Project/Site Name: ABQ North Storage

Stormwater Control Permit for Erosion and Sediment Control

**Re: ABQ North Storage
Erosion and Sediment Control Plan
Engineer's Stamp Date 6-19-18 (resubmittal same stamp date) (F15E052E)**

**Re: ABQ North Storage
Erosion and Sediment Control Plan
Engineer's Stamp Date 6-19-18 (F15E052E)**

EROSION AND SEDIMENT CONTROL PLAN

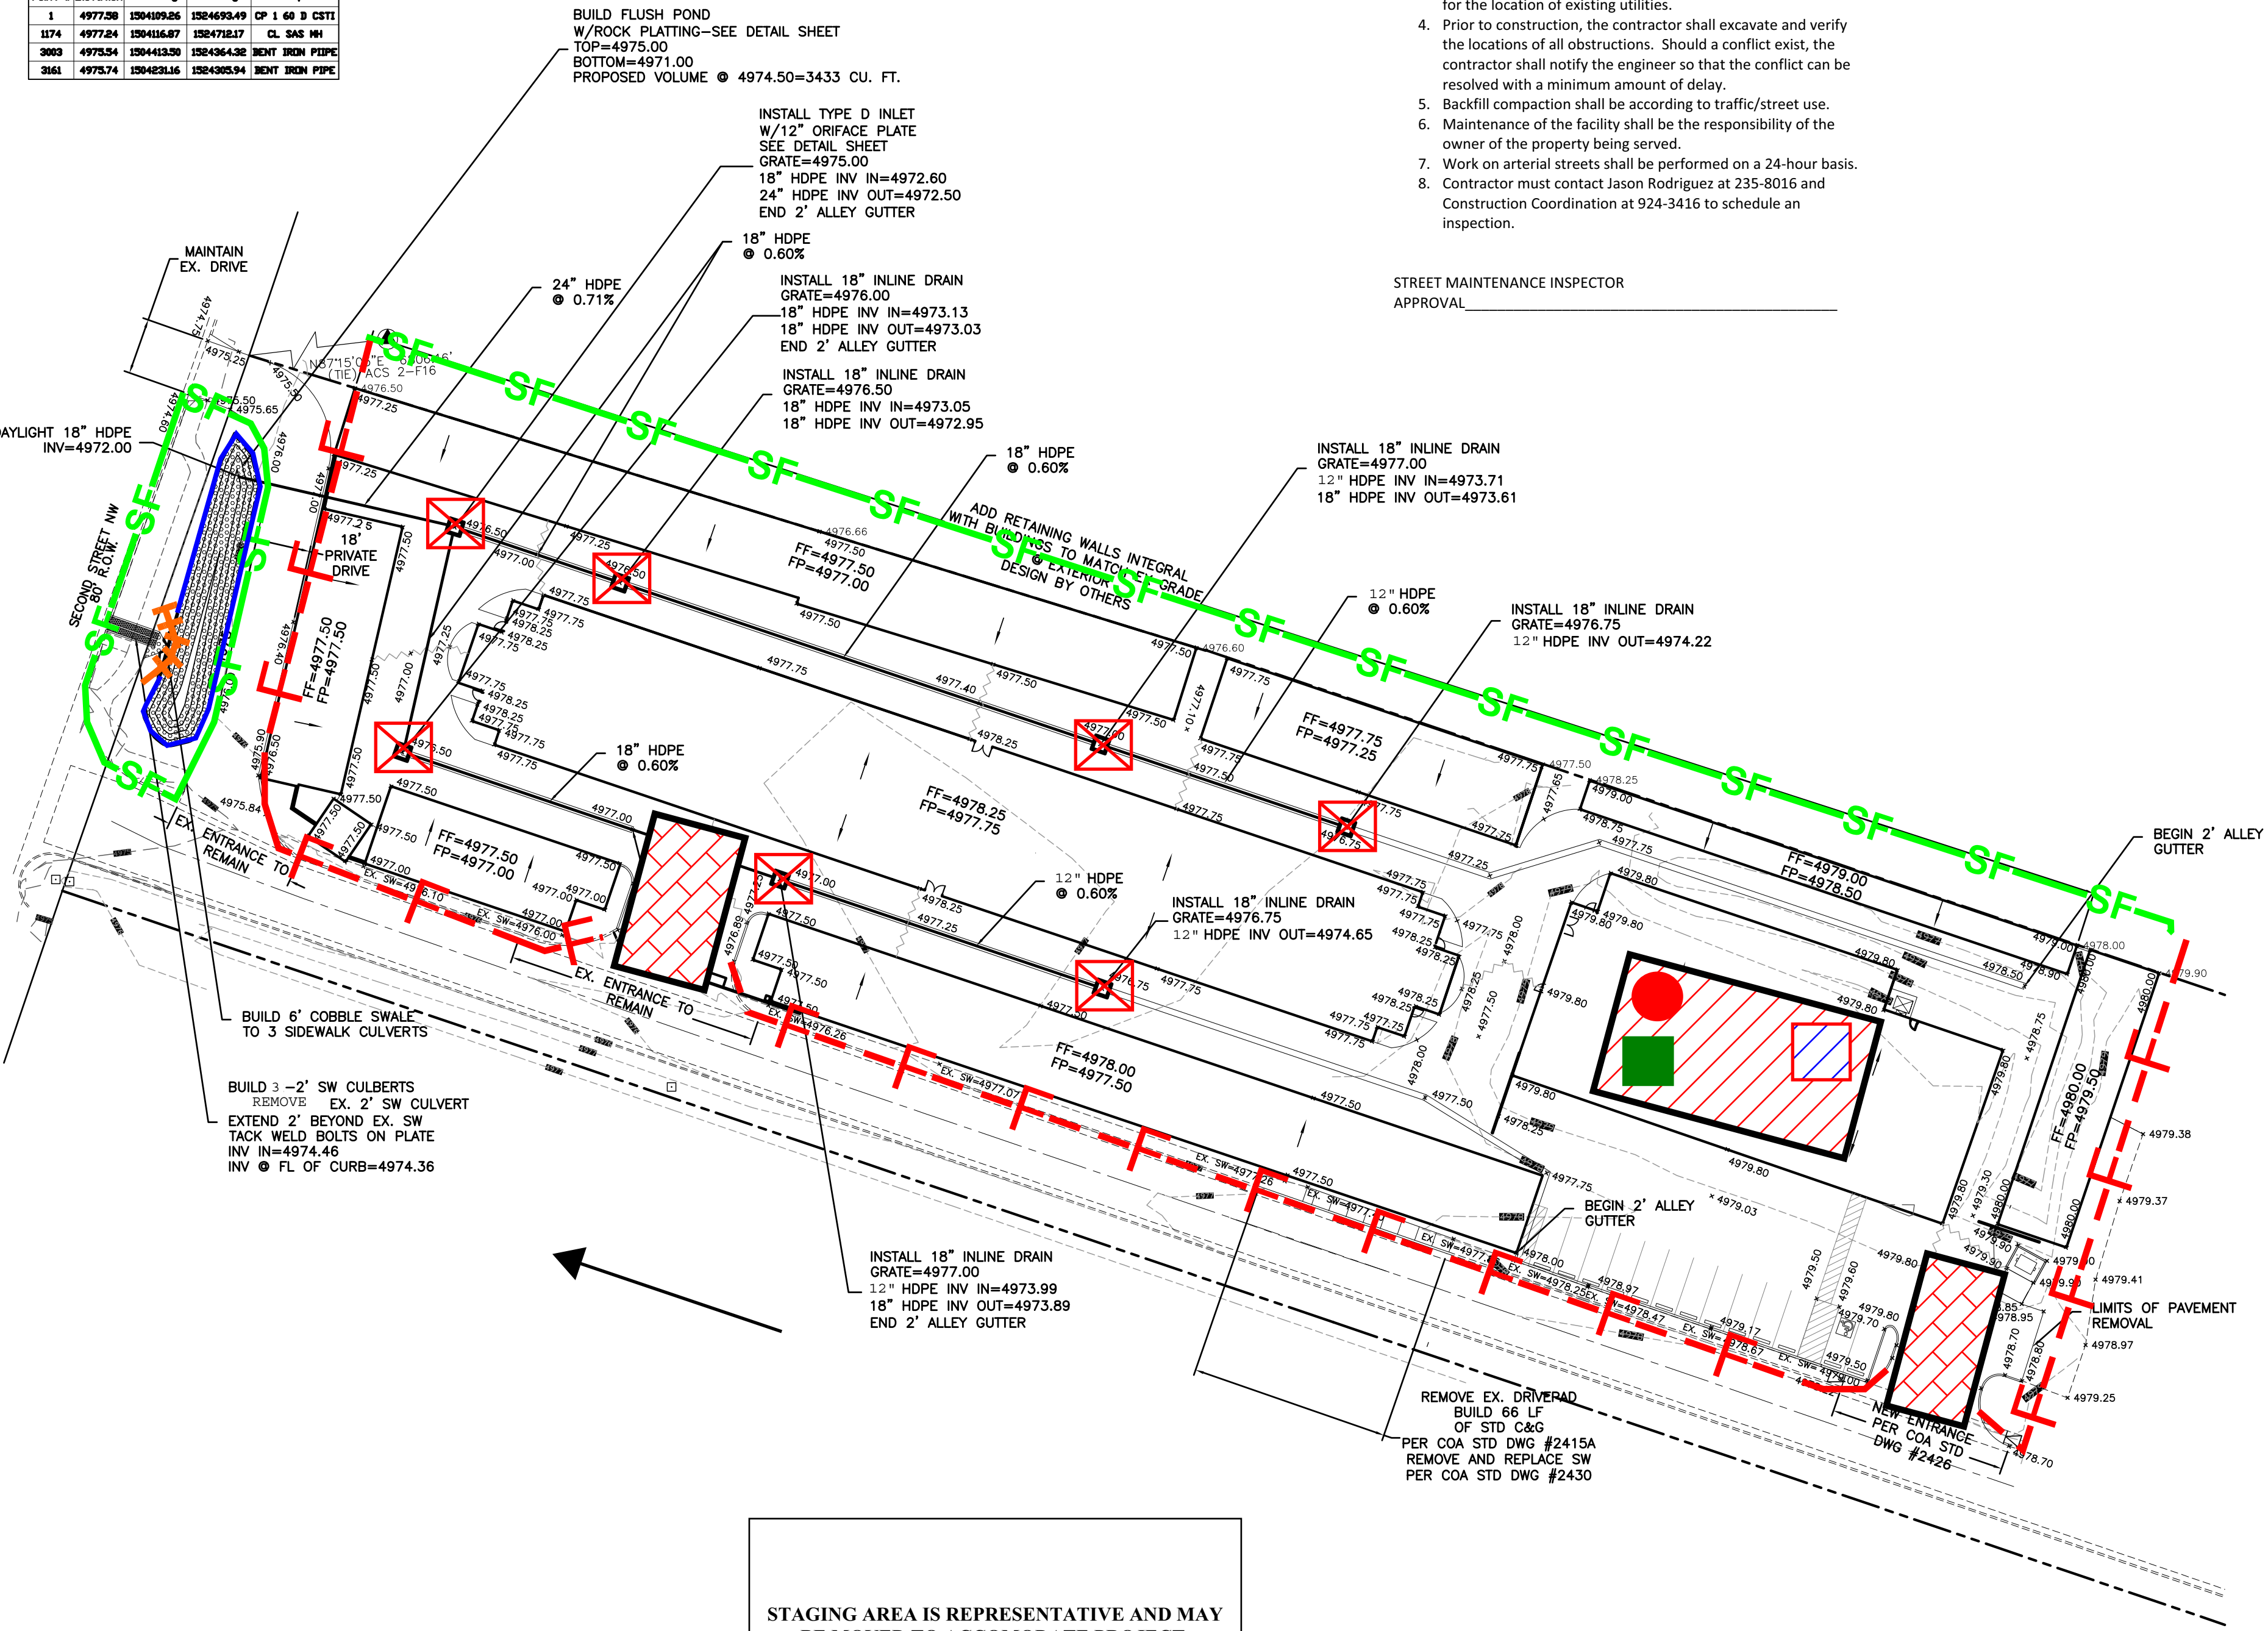
Based upon the information provided in your submittal received 6-20-18, the above referenced plan is not approved to be included in the SWPPP or to apply for an ESC Permit for grading and Building Permit until the following comments are addressed:

1. The fence shown on the plans:
 - a. Has been removed from the existing entrance to the east boundary
 - b. Was not present at the time of my site visit on 6-28-18 along the eastern edge of the project.
 - c. Is to be removed and replaced along the western edge of the project.
 - d. Photos are attached to the e-mail accompanying this letter.
2. Provide a sediment BMP along the south, east and west edges of the site.
3. The silt fence shown around the pond in the western area of the site is proposed across impervious surfaces in some locations. Provide a sediment BMP that will create a seal on an impervious surface, where necessary.
